16th September 2025

**ONE EARTH SOLAR FARM DEVELOPMENT CONSENT ORDER EN010159 – NCC COMMENTS
ON RESPONSES TO LOCAL IMPACT REPORT AT DEADLINE 3 (16 SEPTEMBER 2025)**

Figure 4.1: Barred Route Plan

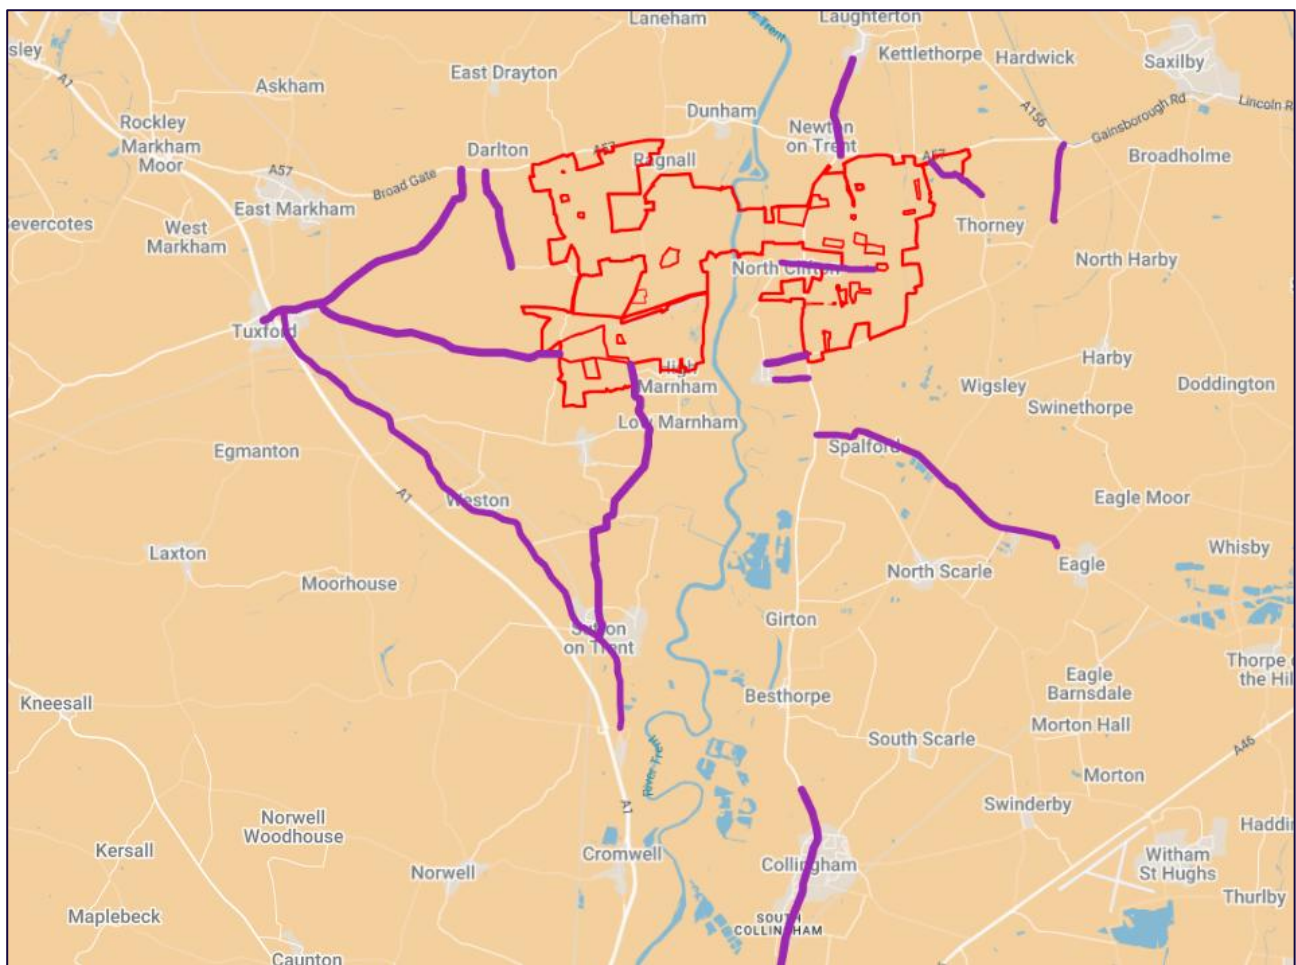
Transport 5.6.3-5.6.35	LIR132	With regards to the additional barred routes, please note that the diagram of the barred routes is referred to in both the TA and and oCTMP as being in Figure 2 but are in Figure 4.1. The figure is helpful to identify potential routes missing and it would be beneficial to include routes leading to South Scarle in these.
Transport 5.6.3-5.6.35	LIR133 LIR134 LIR135	As per response to LIR131, whilst HGVs will not impact the settlement of Collingham, the additional HGVs may impact the smaller settlements along this route. It is not thought likely that addressing this omission would result in any amendments to highway being necessary, but the route will need to be considered in terms of Wear and Tear.
Transport 5.6.3-5.6.35	LIR138	The applicant understands the only access in contention to be the A57 for which an RSA1 is being prepared. However, this is not the case.
